Recommendation Report for Planning Permission

REF NO: AW/84/22/PL

LOCATION: Land to the North
of 276 Aldwick Road
Bognor Regis
PO21 3QH

PROPOSAL: Variation of condition imposed under AW/28/19/PL relating to condition 2-plans condition (updated plans and Arboricultural Impact Assessment and Method Statement.

2021.337.02

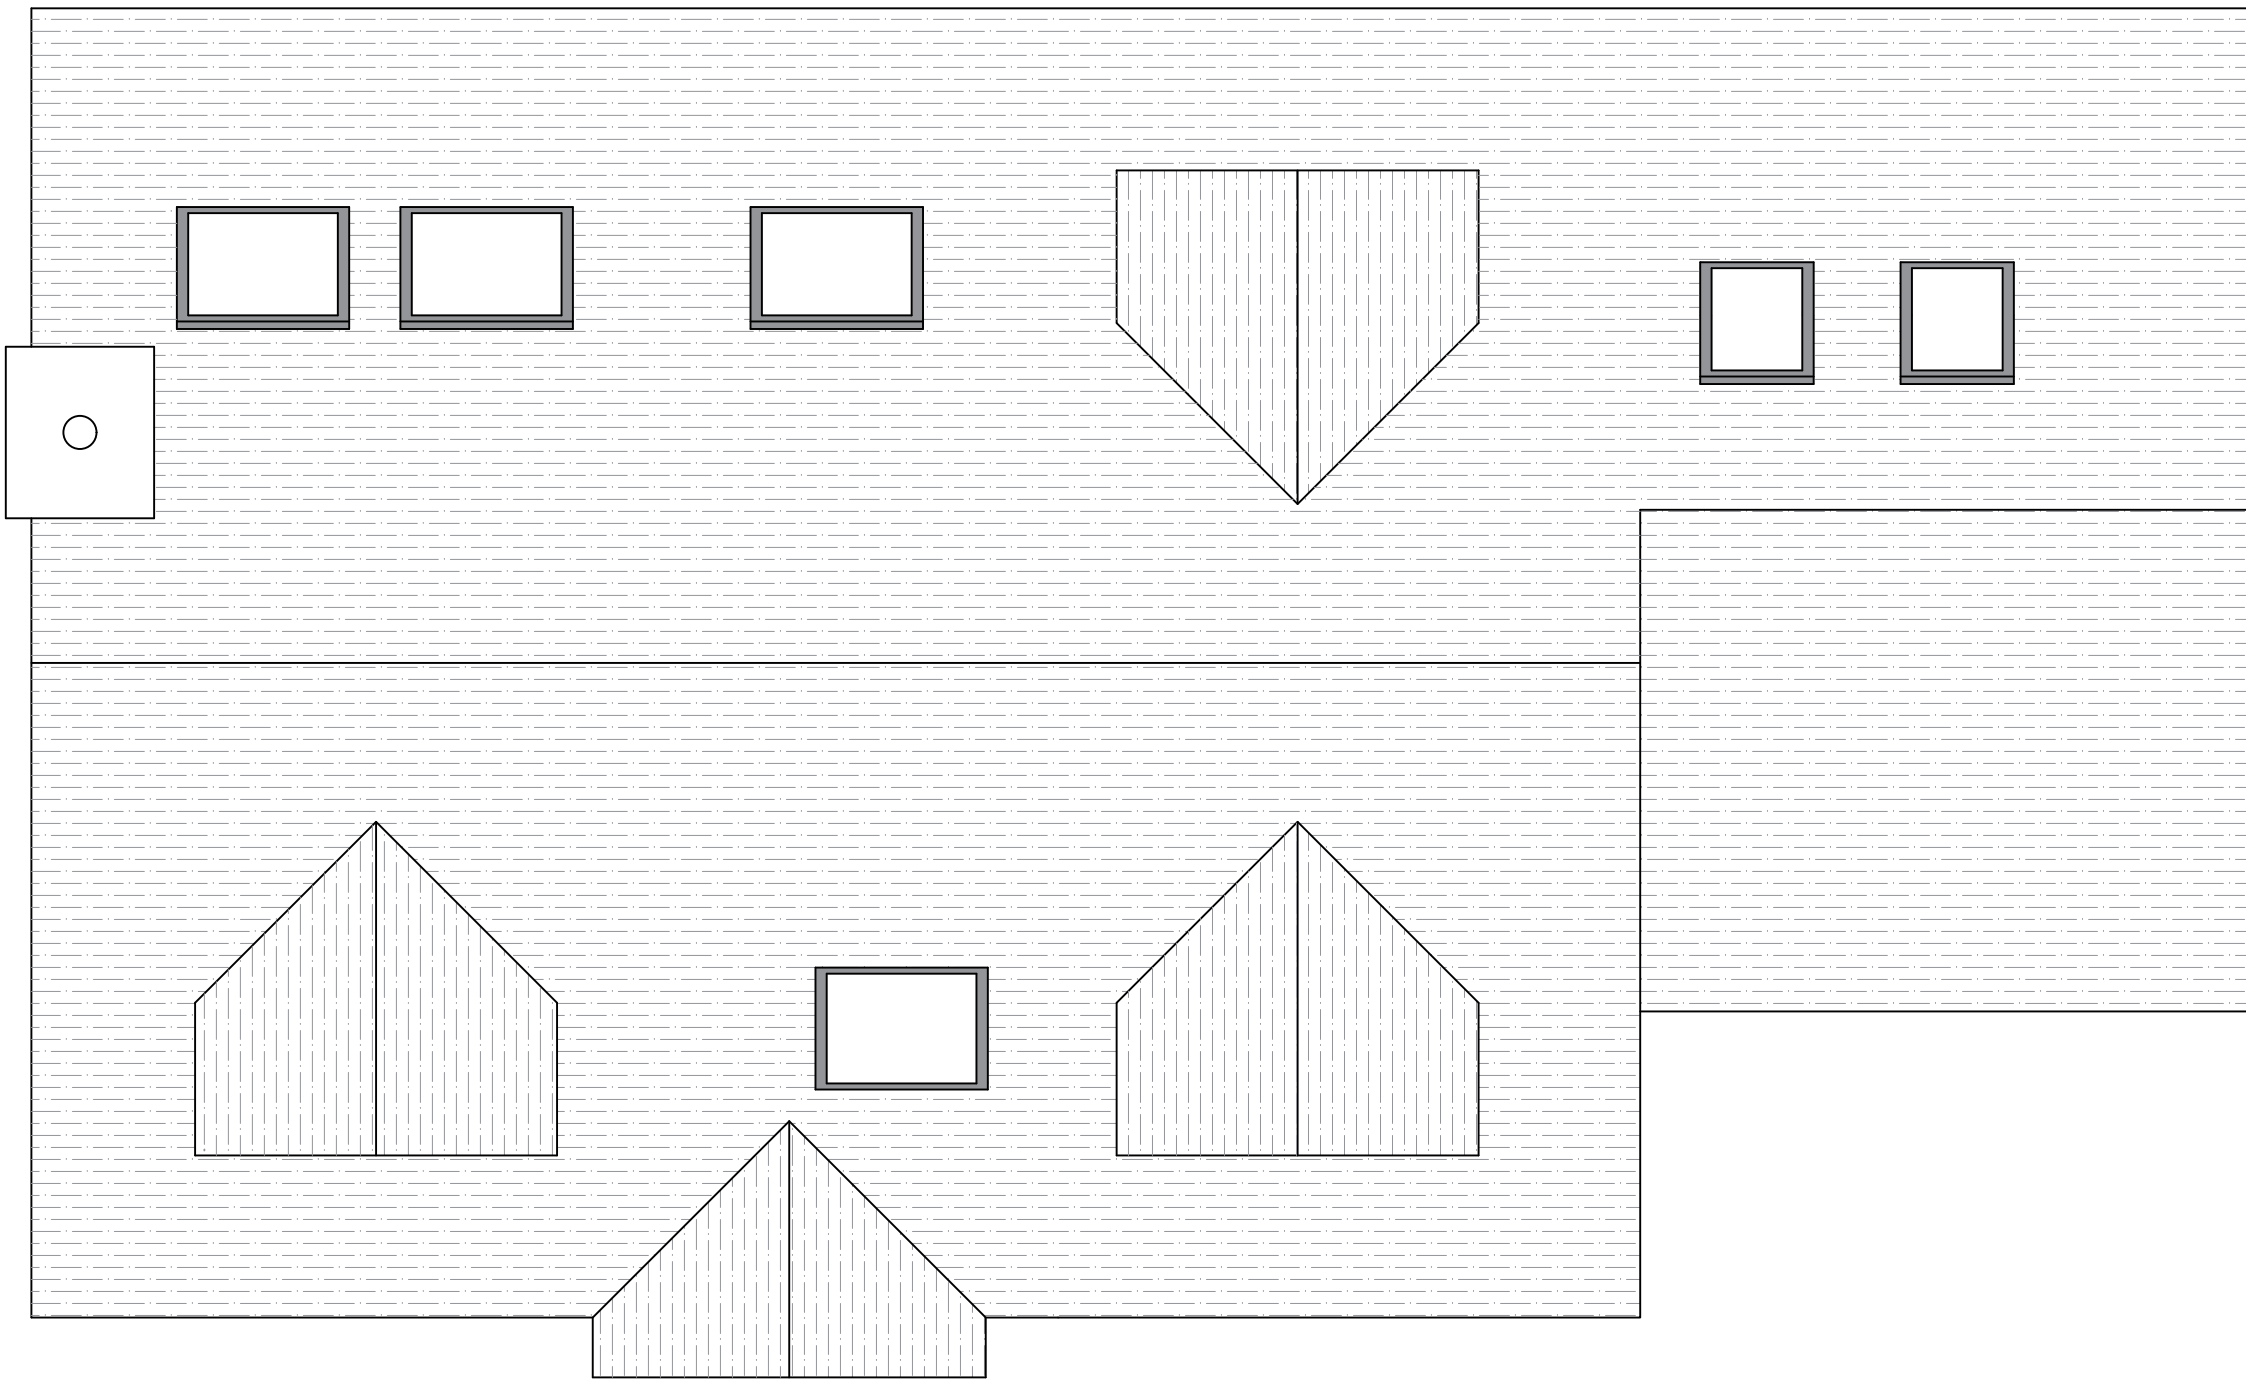
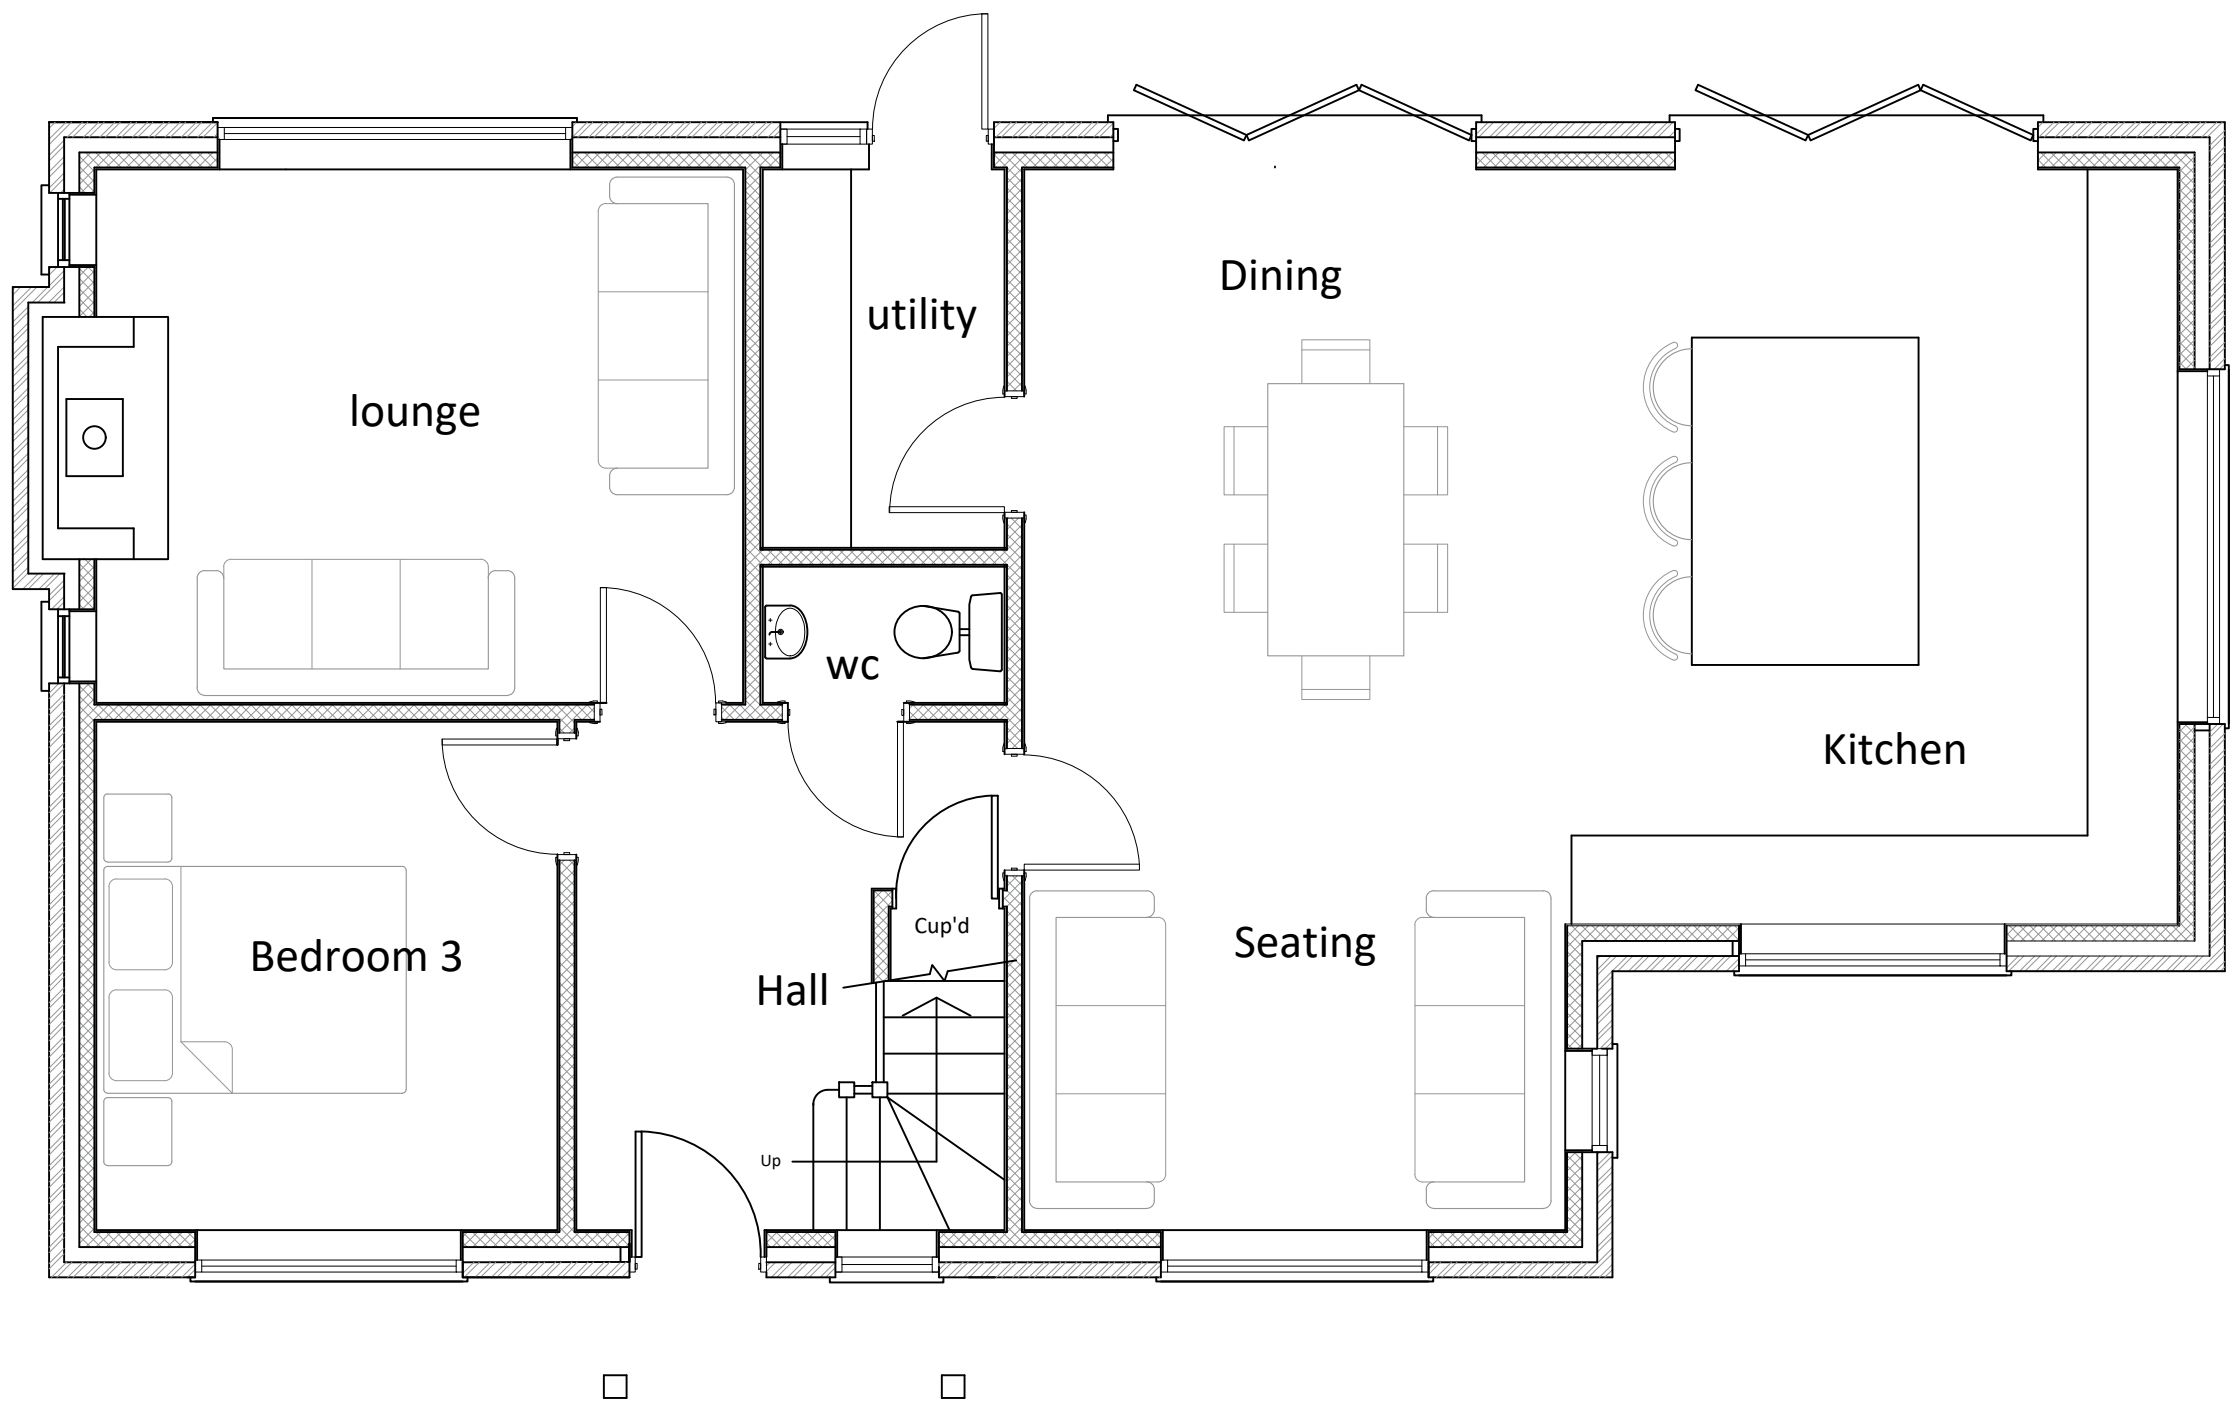
The proposal represents back land development as it is in the rear garden of a dwelling which would face part of Margaret Close. The amendments involve changes to fenestration of the approved dwelling. Two smaller roof-lights on the western roof plane would be replaced with one larger one, a side window of the entrance door would be replaced with a side whole height window, the size of windows would be adjusted to the size of the windows on the side projection and two small roof-lights would be inserted to the roof plane above it. Two small roof-lights would be inserted to the eastern roof plane of side projection and three larger to the eastern roof plane of the main building to the right of an approved dormer. The window on east elevation of the side projection and French doors of the main building would be replaced with bi-folding doors. A large casement window would replace two small windows on this elevation. A chimney is proposed on the northern elevation. To level the difference between the garden and the ground floor two stairs are proposed on the rear elevation to access the bi-fold doors.

The changes would not be readily visible from the public view, except the chimney which is a common feature of the area.
